**RE: 6/2019/2714/OUTLINE – 1 YMCA, 90 Peartree Lane, Welwyn Garden City, AL7 3UL**

Thank you for your re-consultation in relation to the above planning application for the outline planning application for a hybrid application for demolition of existing hostel, development of a four storey 100 bed YMCA Hostel (All details submitted for determination) and a 2,3 and 4 storey building providing up to 43 residential apartments (All details retained for future determination as reserved matters, except means of access) with associated car parking and landscaping, at 1 YMCA, 90 Peartree Lane, Welwyn Garden City, AL7 3UL.

Sana Shaikh  
SuDS Officer  
Hertfordshire County Council

Recommended soil infiltration rate

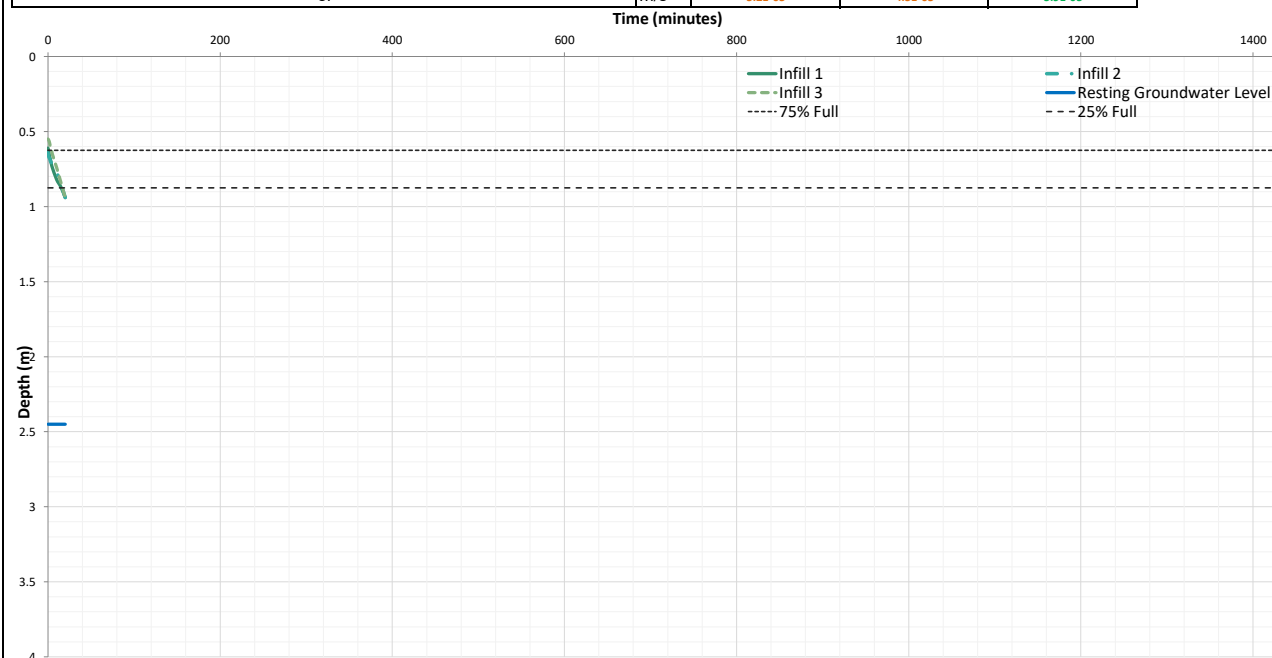
We note that infiltration testing has been carried out onsite and Soil Infiltration rates of  $4.5 \times 10^{-5}$  m/s (good infiltration rate) and  $7.0 \times 10^{-6}$  m/s (poor infiltration rate) was found. A site-specific environmental report was produced by Delta-Simons in April 2020 to investigate for any potential risk of groundwater contamination. No significant source of contamination was found. Based on this infiltration rates and the location of the developments, the proposed surface water strategy involves the division of the entire site into two separate surface water networks.

1. Detailed infiltration testing in accordance with BRE Digest 365 at the proposed depth and location of the proposed SuDS feature
2. Provision of additional ground investigations to assess the potential for solution features.
